EPC STORMWATER REVIEW COMMENTS
IN ORANGE BOXES WITH BLACK TEXT

FALCON AREA WATER/WASTEWATER AUTHORITY

BAR-X PIPELINE SEGMENT A2 EROSION CONTROL

PCD File No. **CDR248**

Proj.#: W0242.22004
 Date: 09/26/24
 Design: JPM
 Drawn: AMY
 Check: JPM
 SHEET NUMBER
EC-01

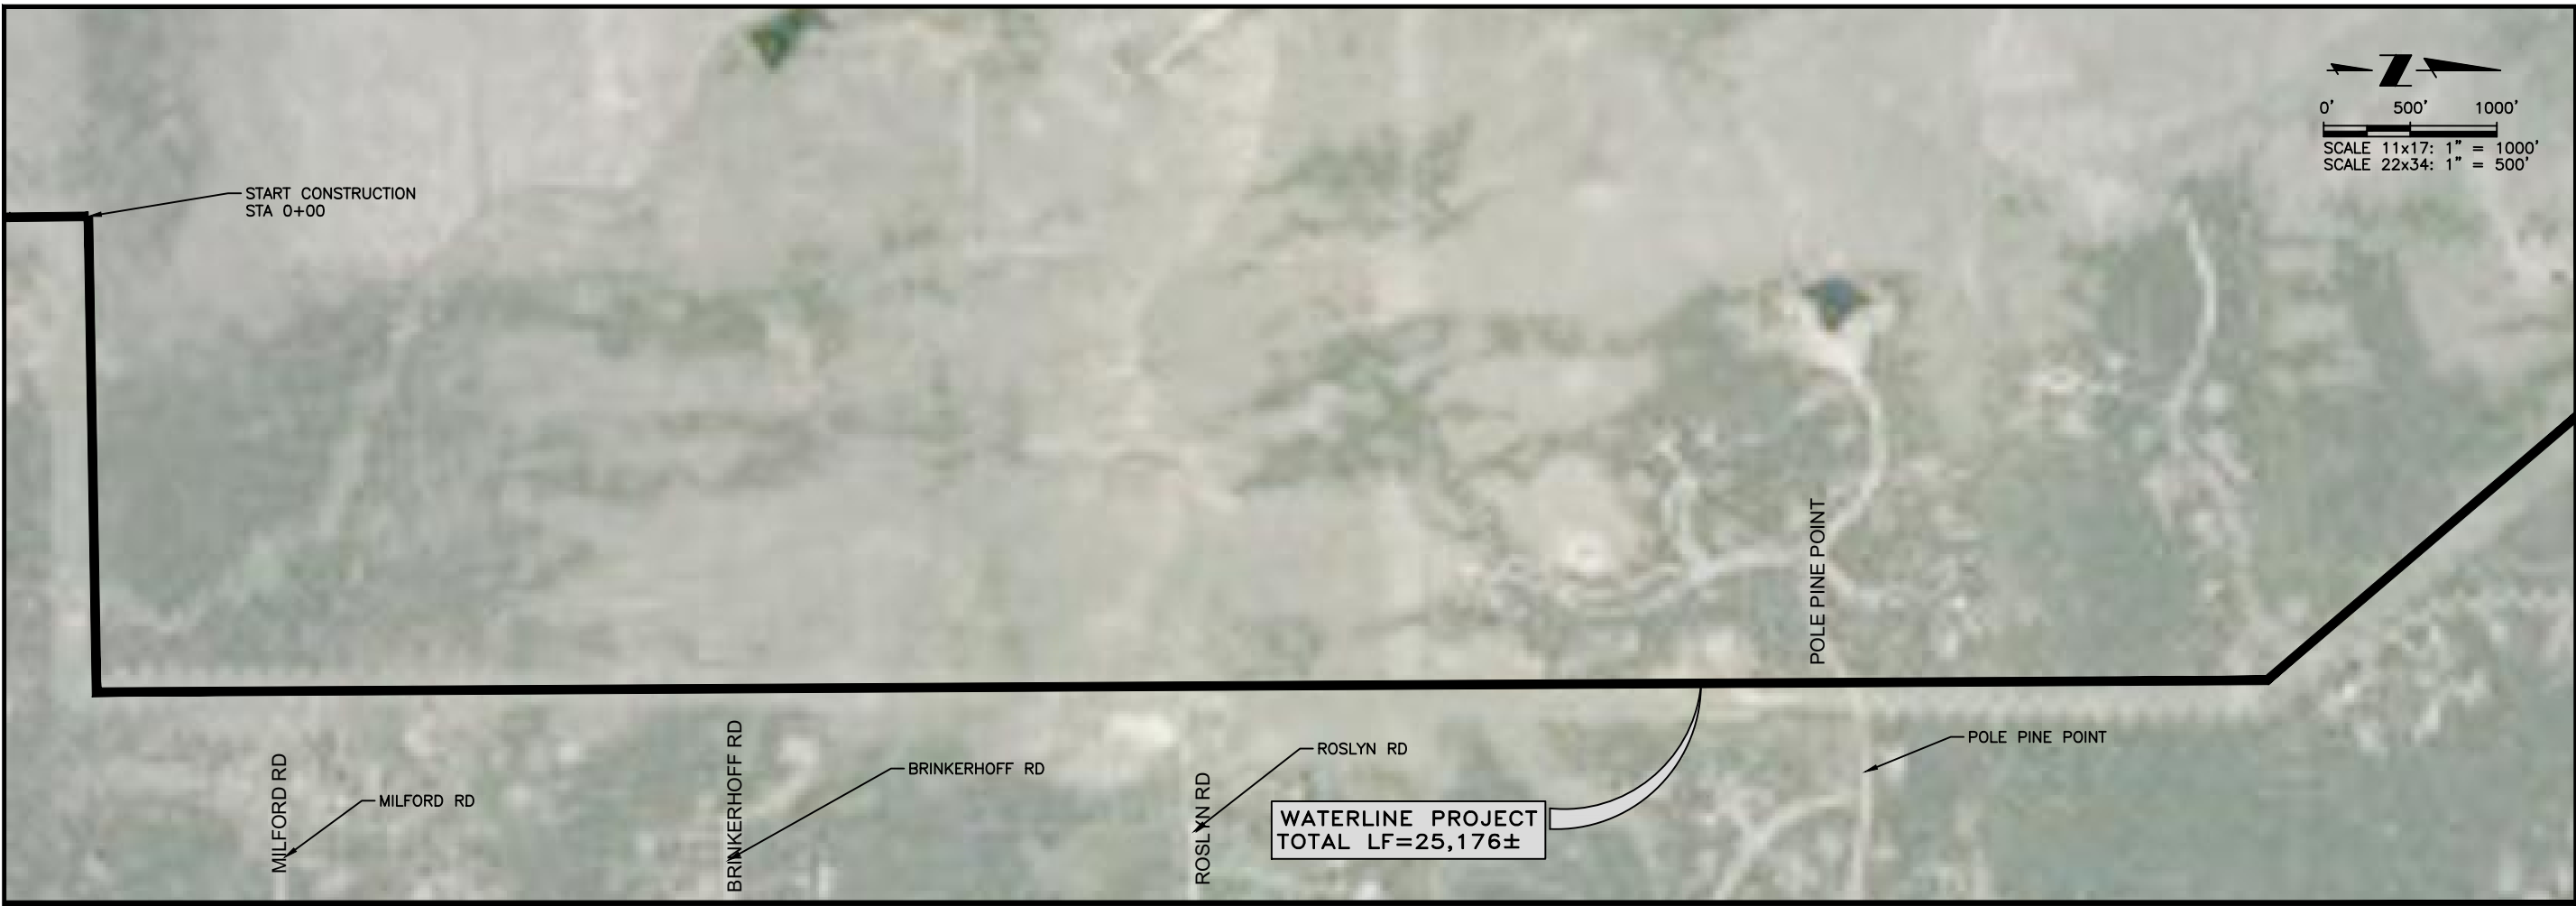
What ROW Please clarify

SHEET NUMBER
EC-04

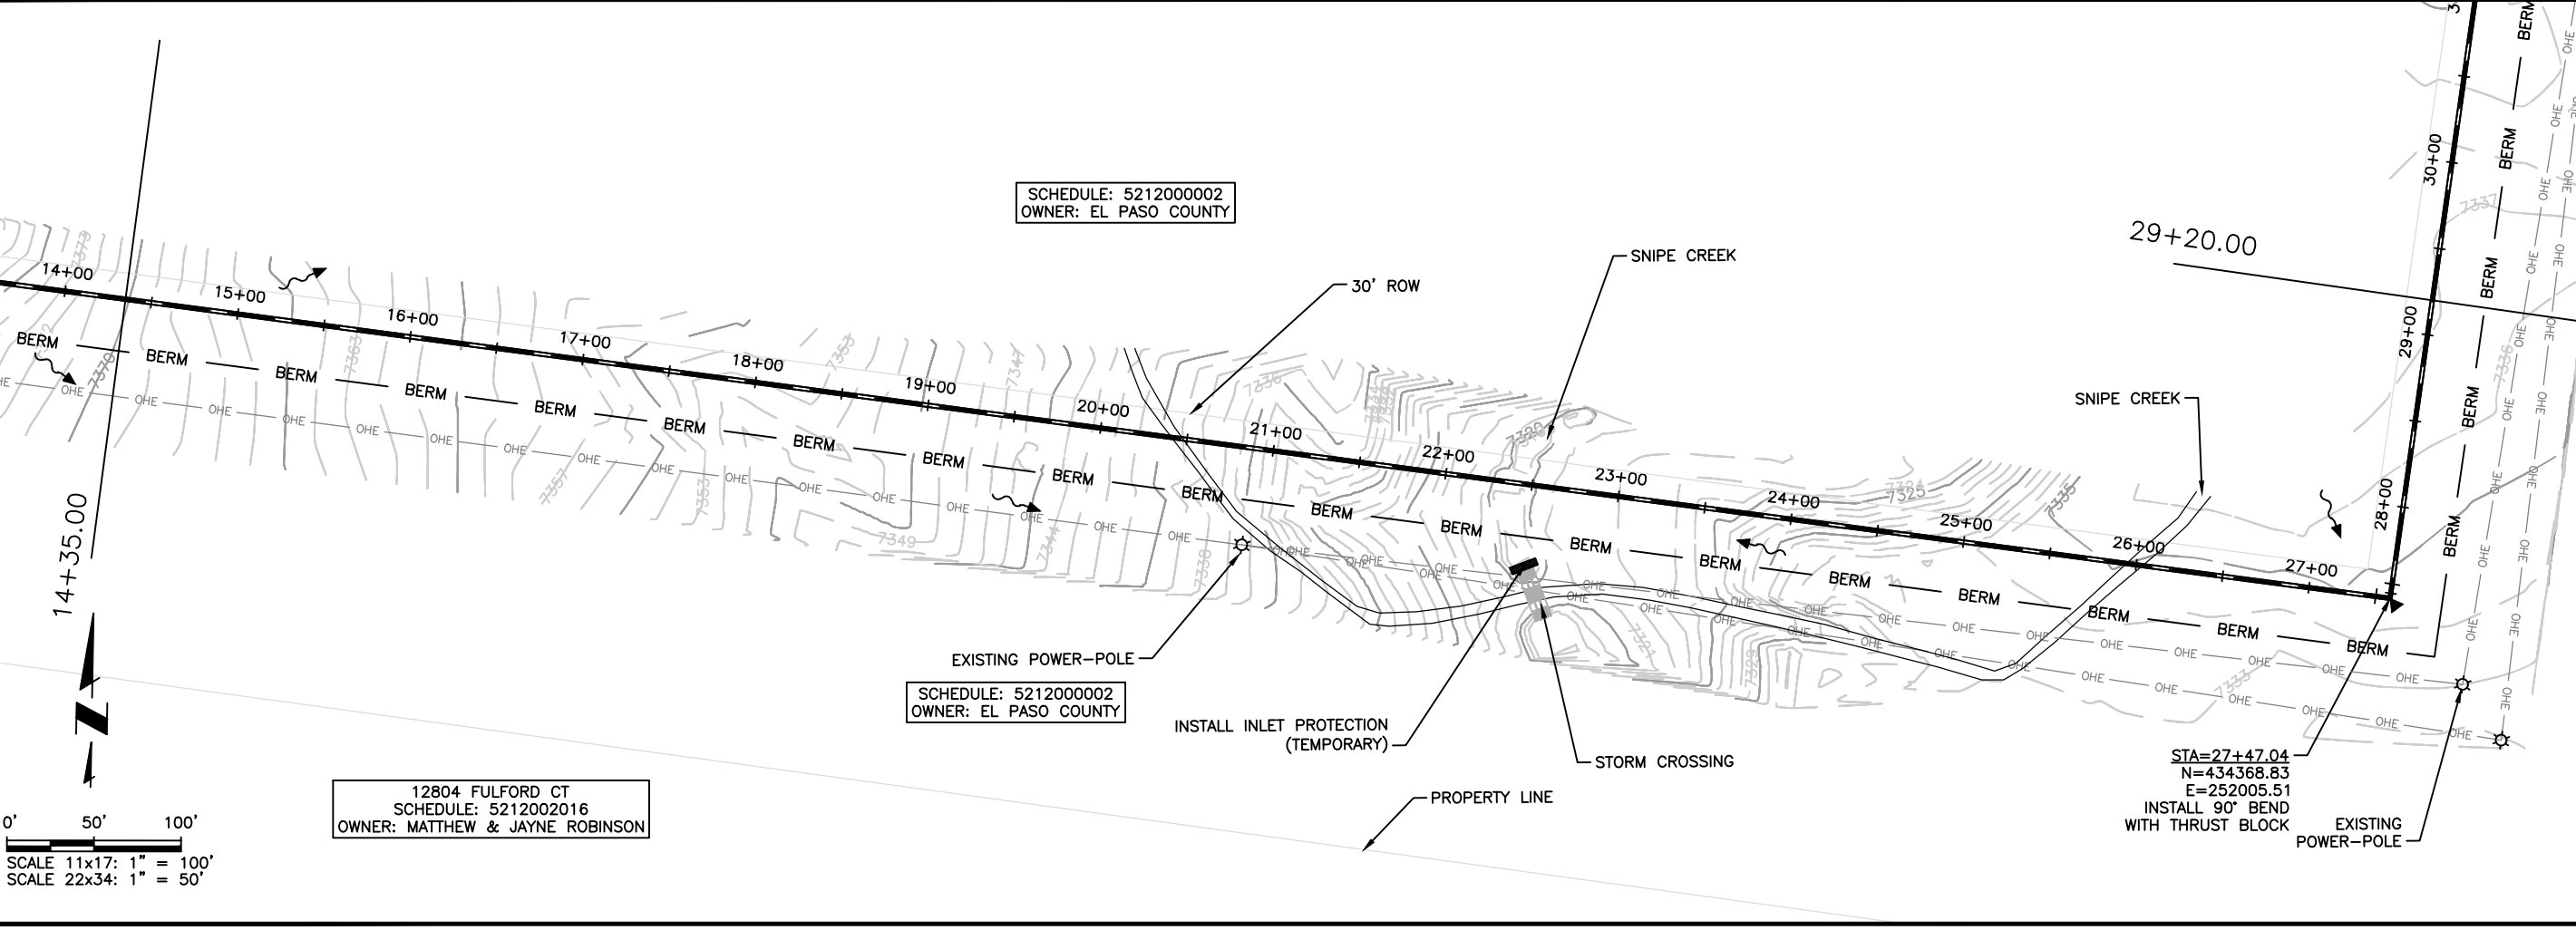
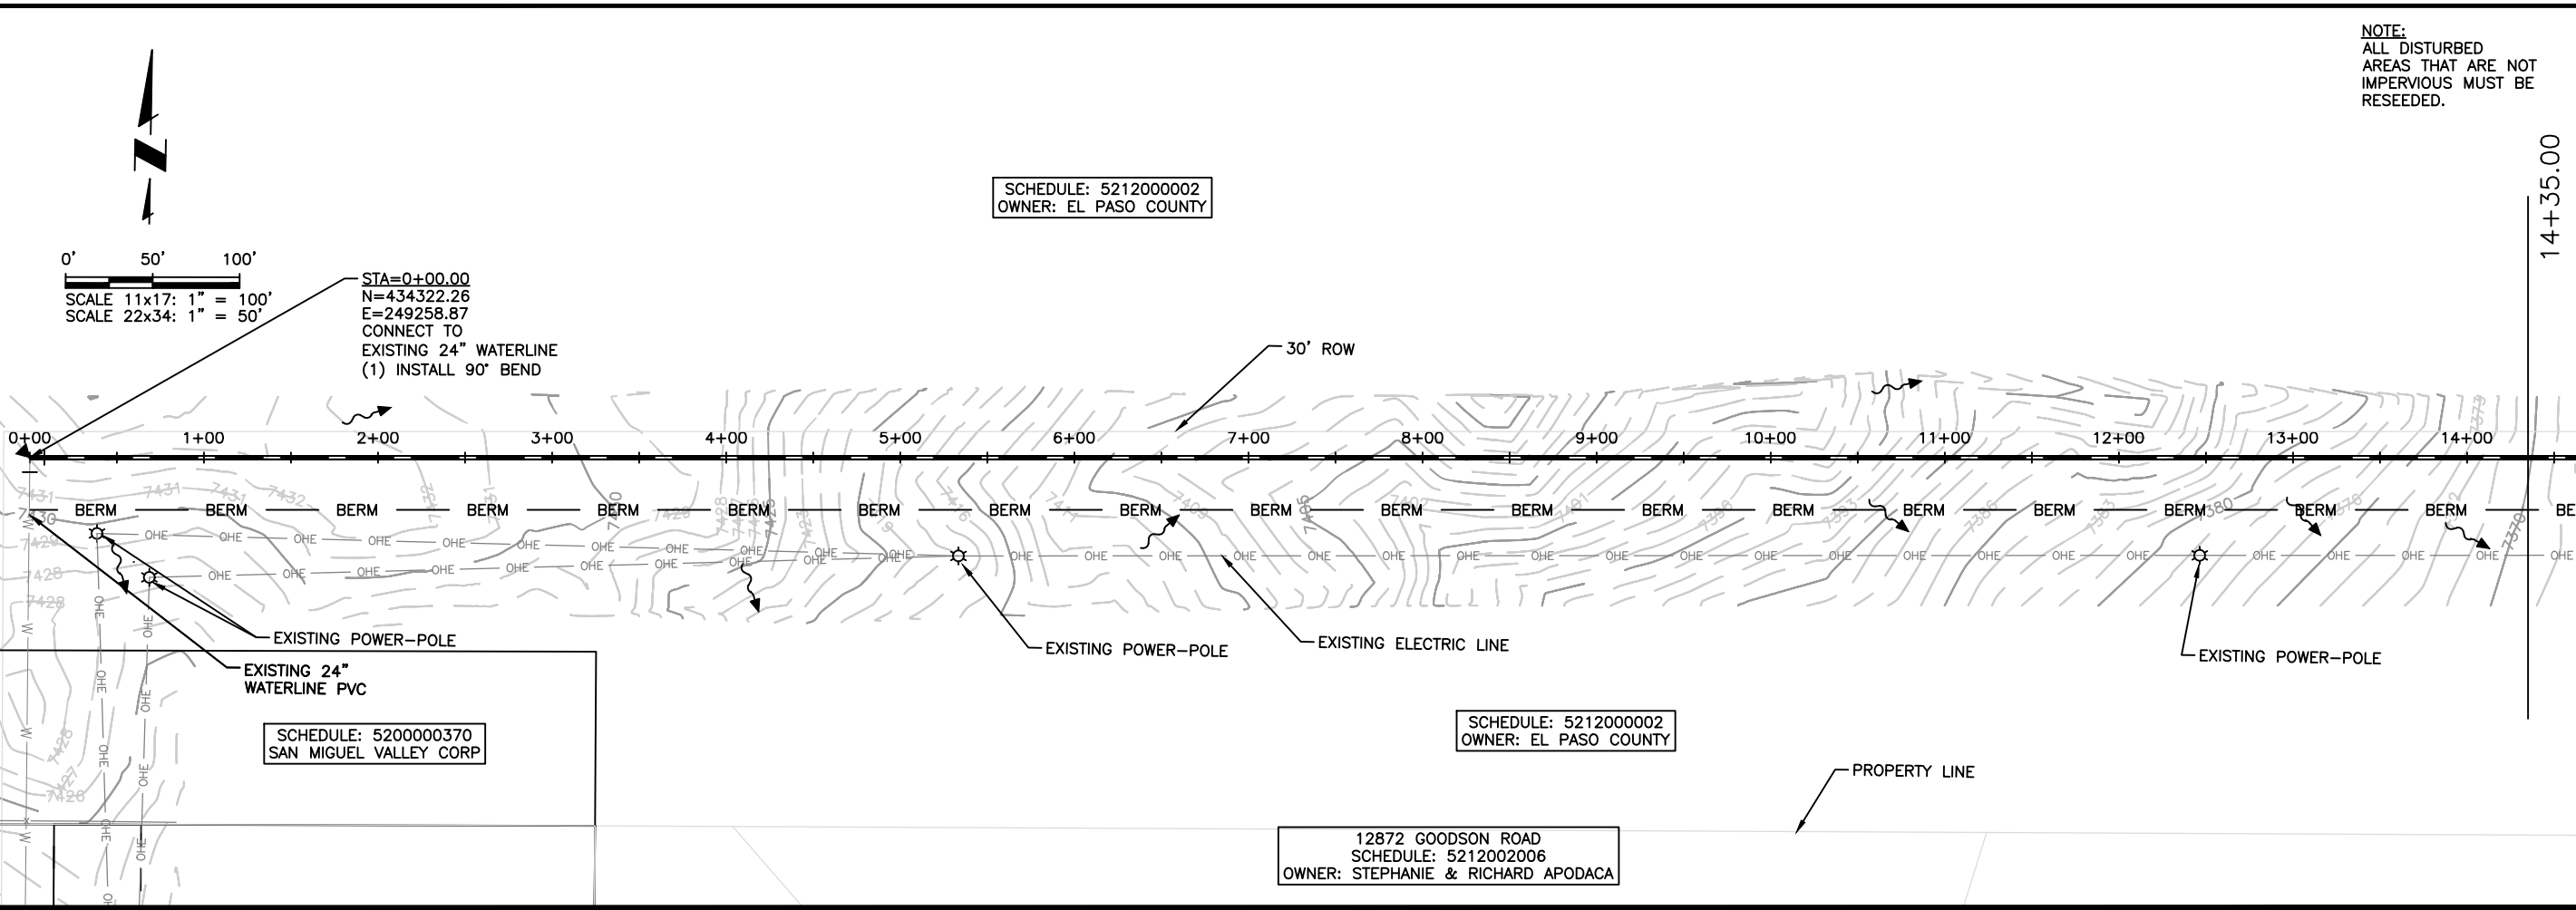
Where are the limits of this ROW? I can only see one line. Where are the temporary construction easements for the projects? Later sheets show them. All easements need to be clearly labeled and shown. Typical comment.

The FAE and detail sheets show additional BMPs. Show all on these plans

This appears to be a low spot along the proposed berm BMP. The berm at this location should be broken up and because flow will concentrate here riprap or other dispersement method likely is required to prevent erosion. Typical comment for all low spots.

GEC Checklist Item y - Will temporary stream crossings or temporary stream diversions be required? Add note clarifying the proposed plan for work across the stream crossings throughout the project site.

SHEET NUMBER
EC-05

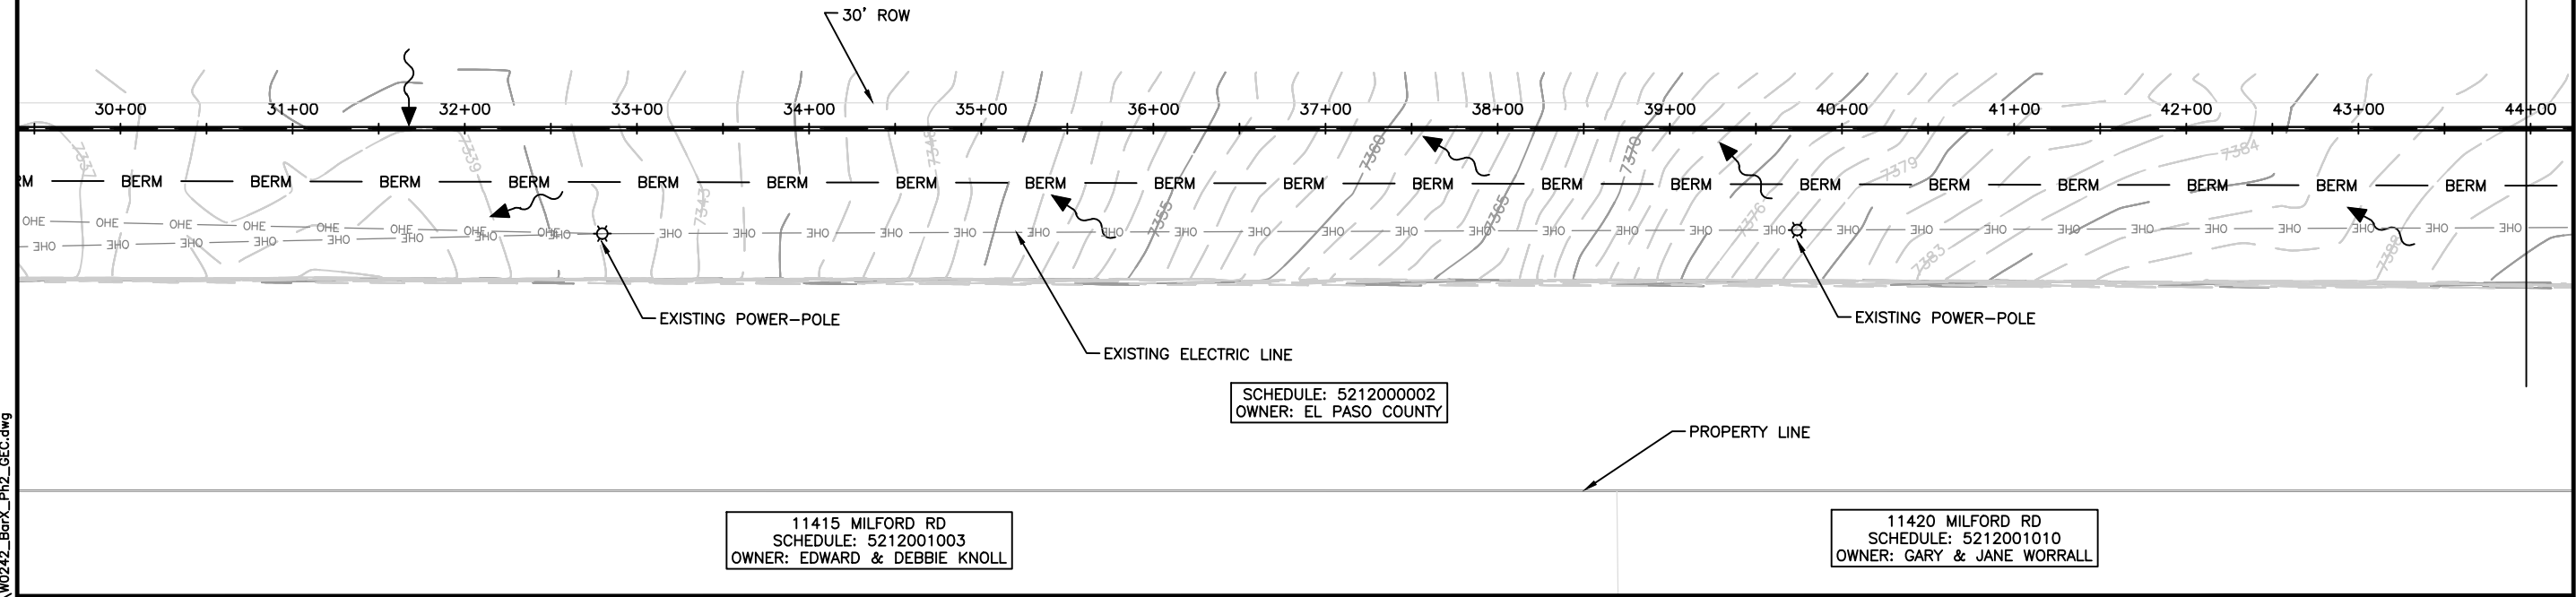
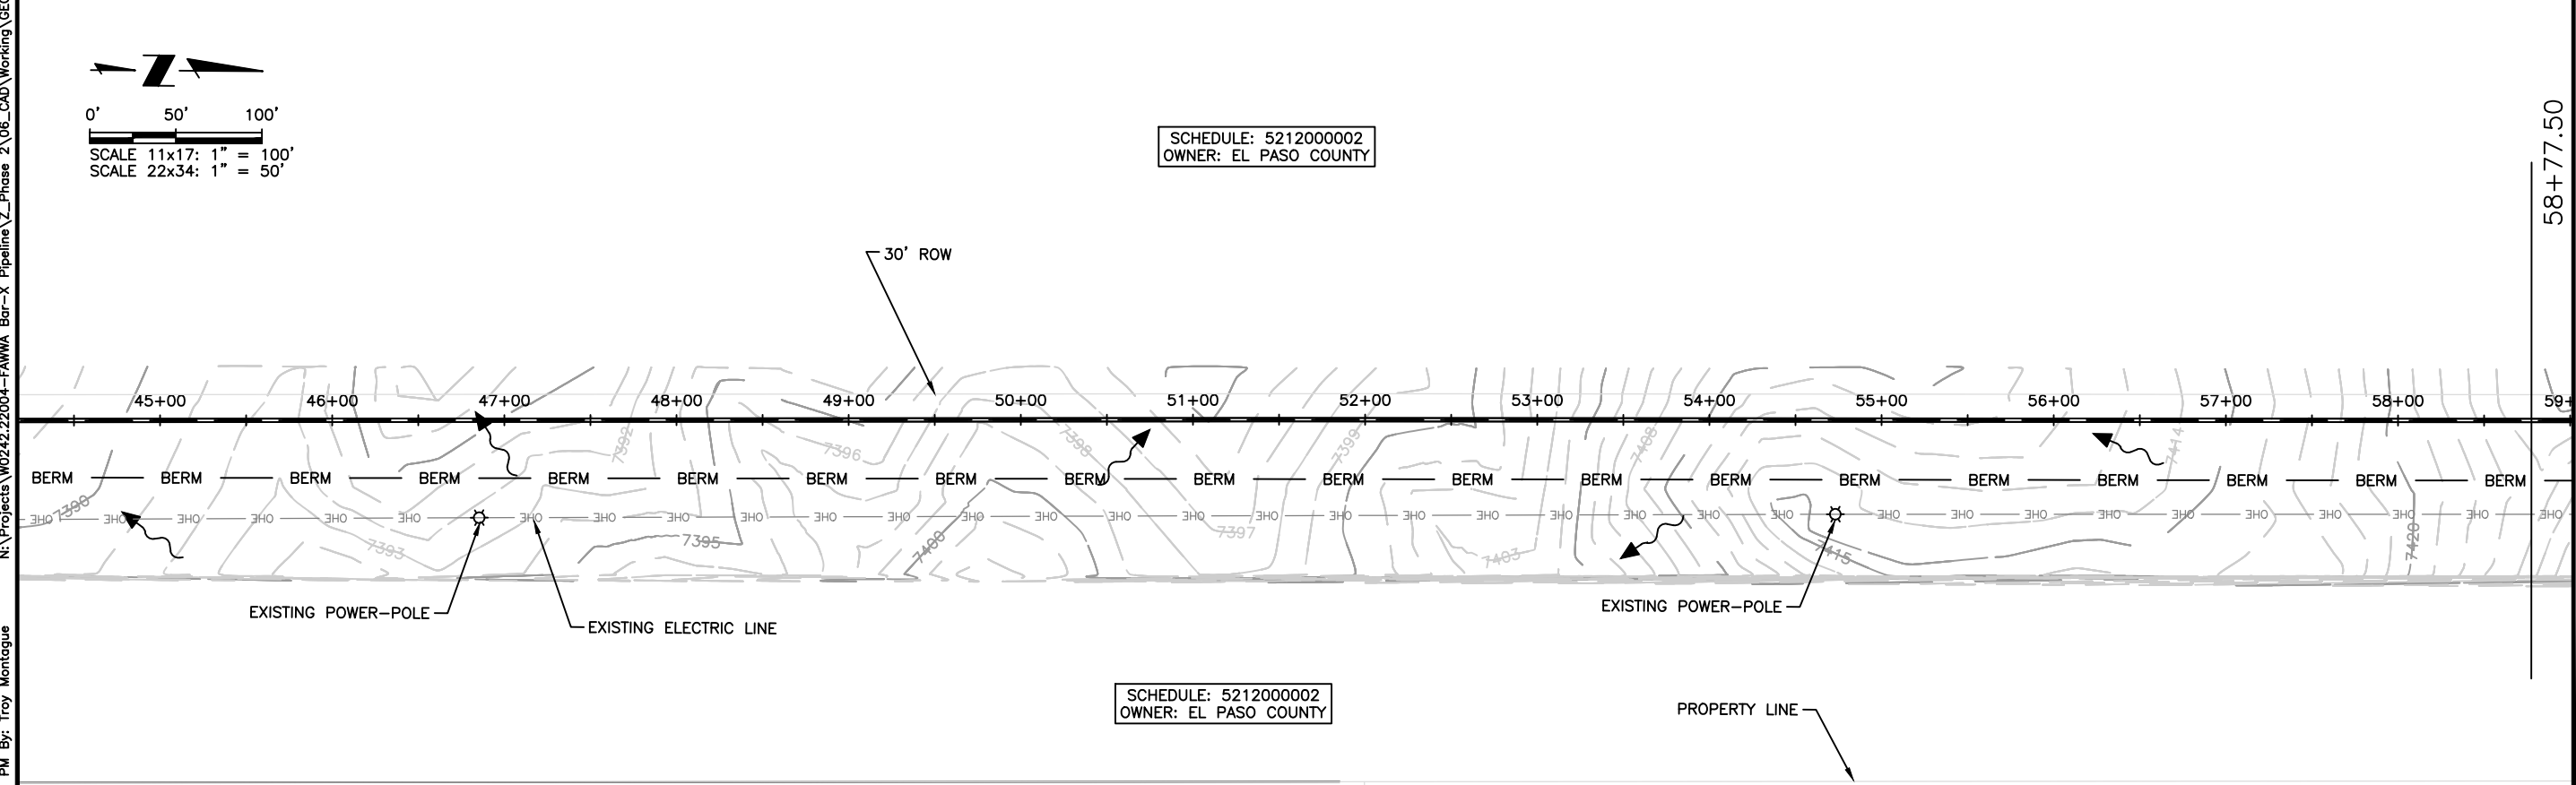
This appears to be a low spot along the proposed berm BMP. The berm at this location should be broken up and because flow will concentrate here riprap or other disperement method likely is required to prevent erosion. Typical comment for all low spots.
